Development Control
Burnley Borough Council

Your ref 3/2024/0234
Our ref D12/3/2024/0234
Date 17th May 2024

Address: 23 Pendleton Road Wiswell BB7 9DD

**Proposal: Proposed demolition of garage and outbuilding.
Construction of two-storey extension to side and single
storey extension to rear. Creation of new window on side
elevation and creation of new parking area.**

SHEET: EXISTING AND PROPOSED
SITE PLAN

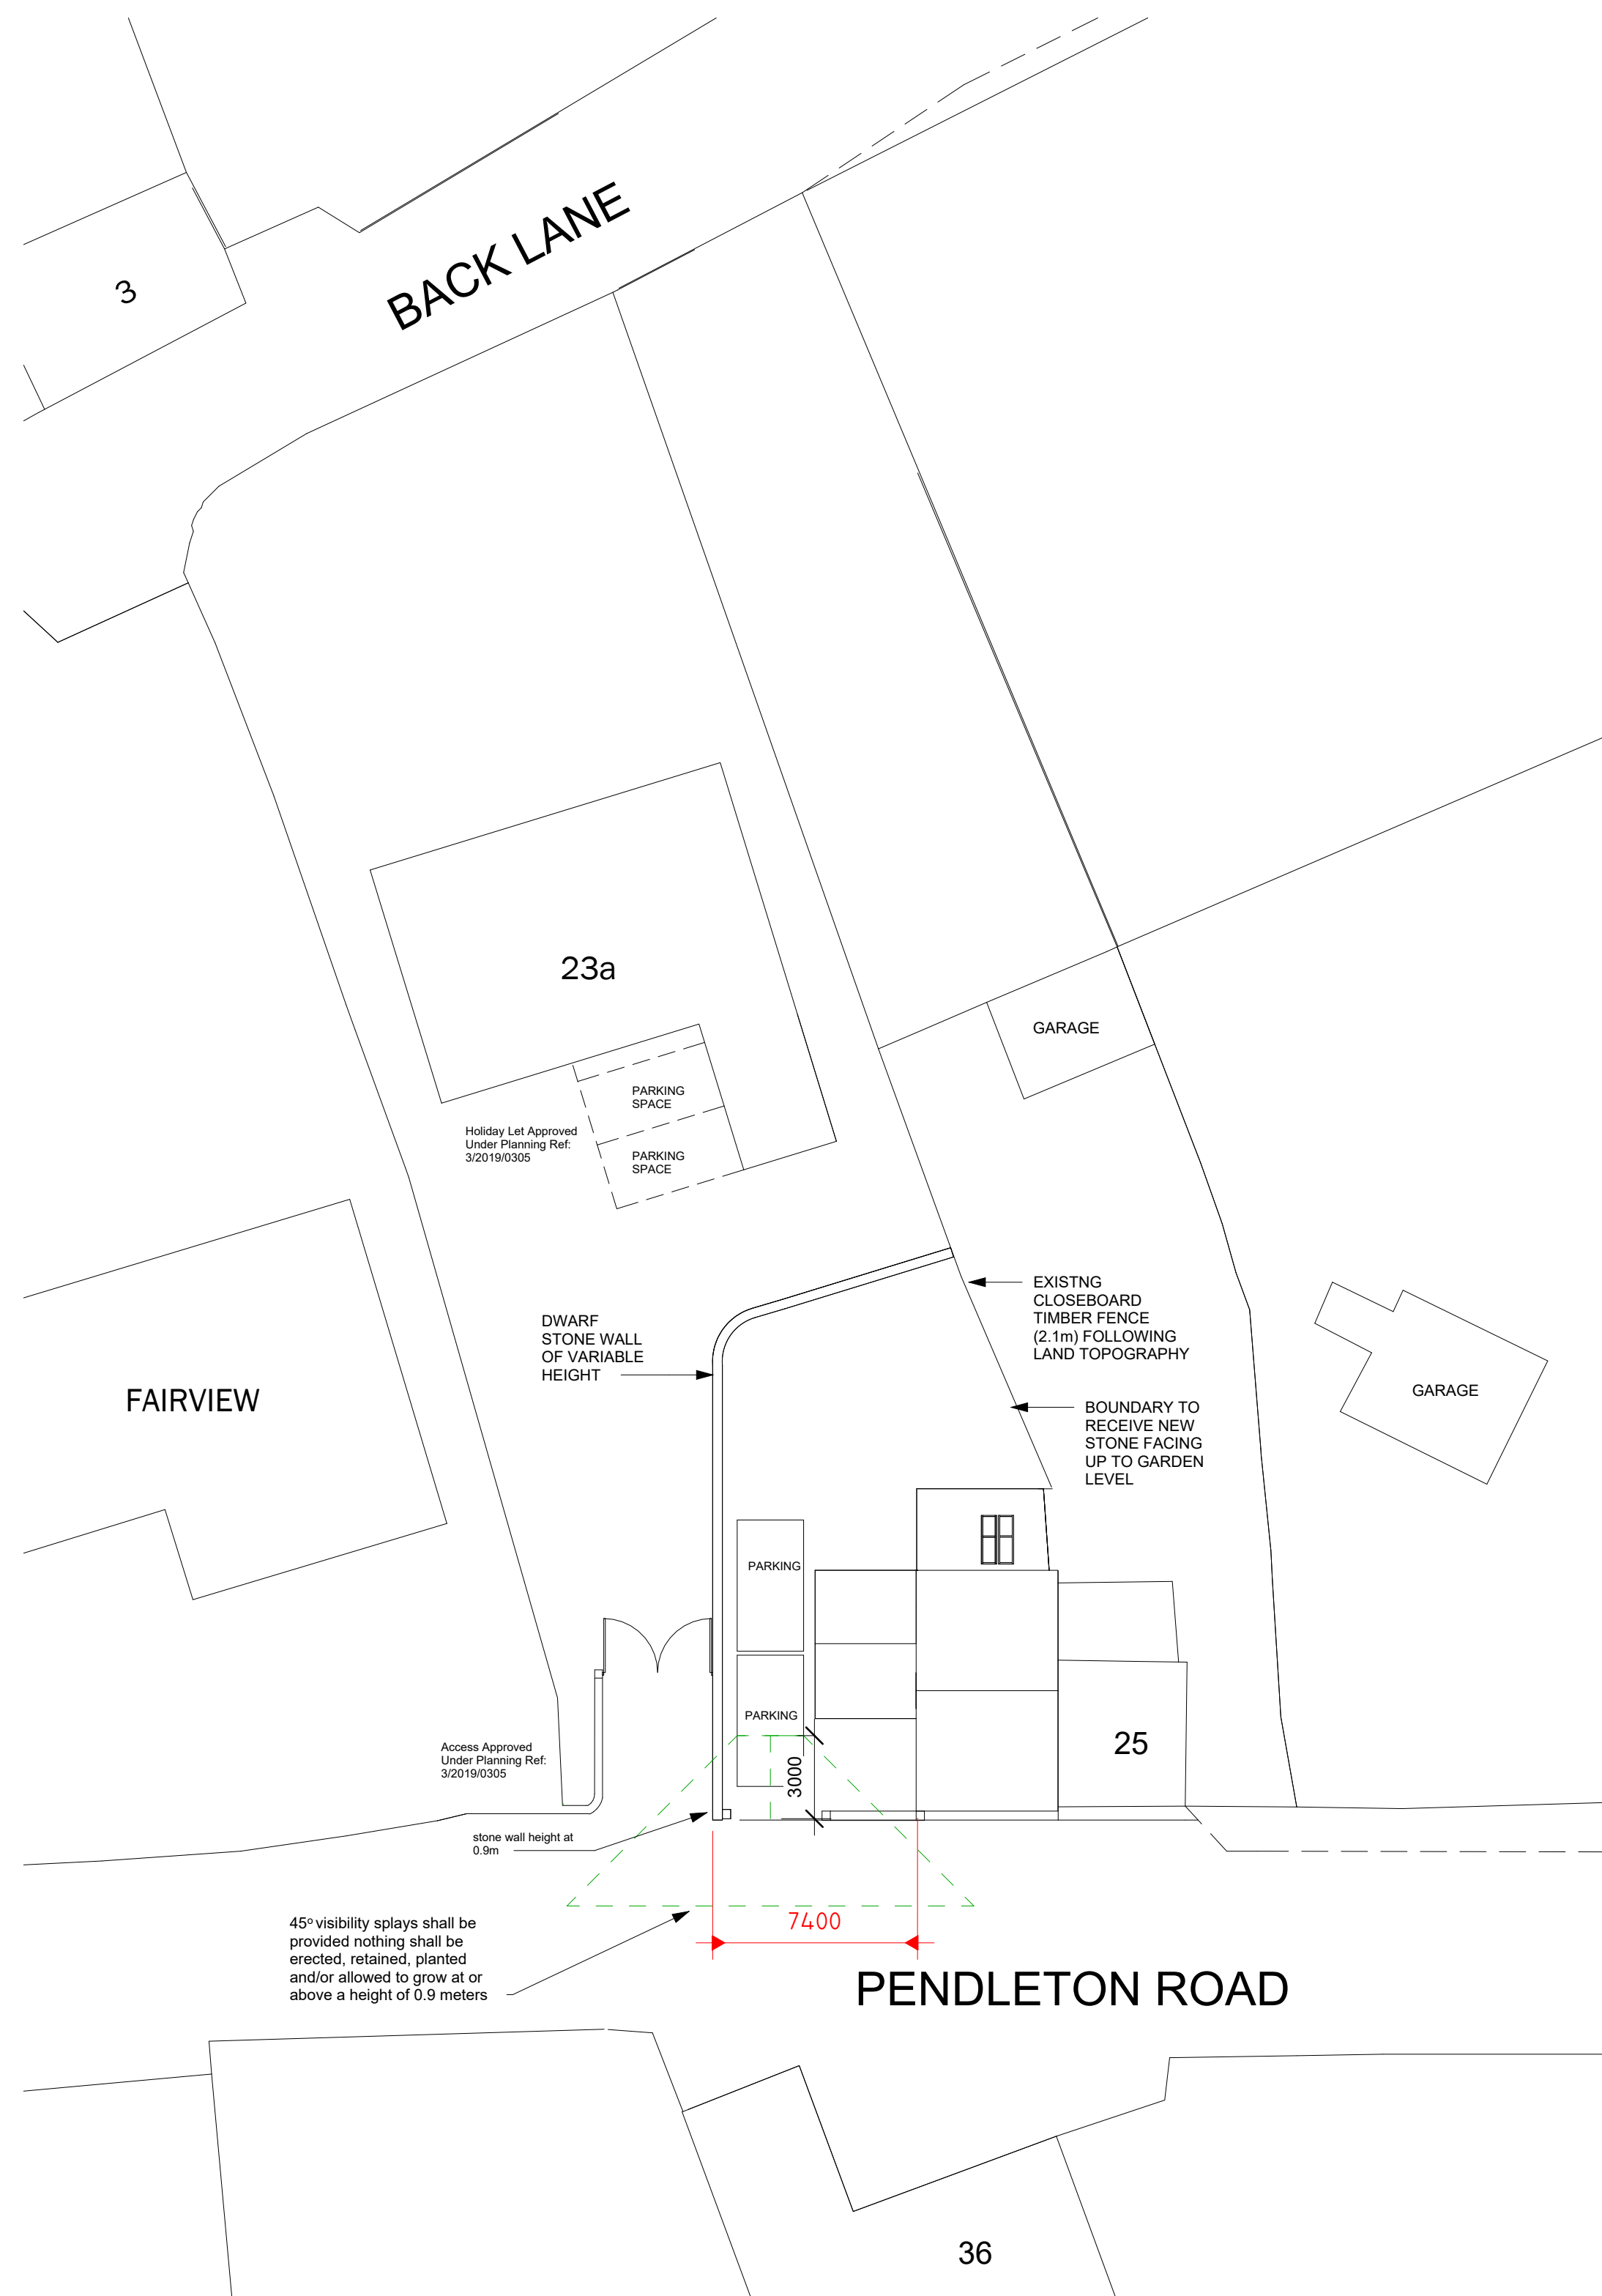
A plan showing the available visibility splays has been provided the annotation states that nothing will be allowed to grow or be built above 0.9m. this will ensure that the splays are kept clear of obstruction.

The surface water from the approved driveway/hardstanding/car park should be collected within the site and drained to a suitable internal outfall. Prior to commencement of the development details of the drainage strategy shall be submitted to and approved in writing by the Local Planning Authority. The scheme shall be implemented in accordance with the approved details.

No building or use hereby permitted shall be occupied or the use commenced until the car parking area has been surfaced or paved in accordance with a scheme to be approved by the Local Planning Authority and the car parking spaces and manoeuvring areas marked out in accordance with the approved plan. The car parking area shall thereafter be kept free of obstruction and available for the parking cars at all times.
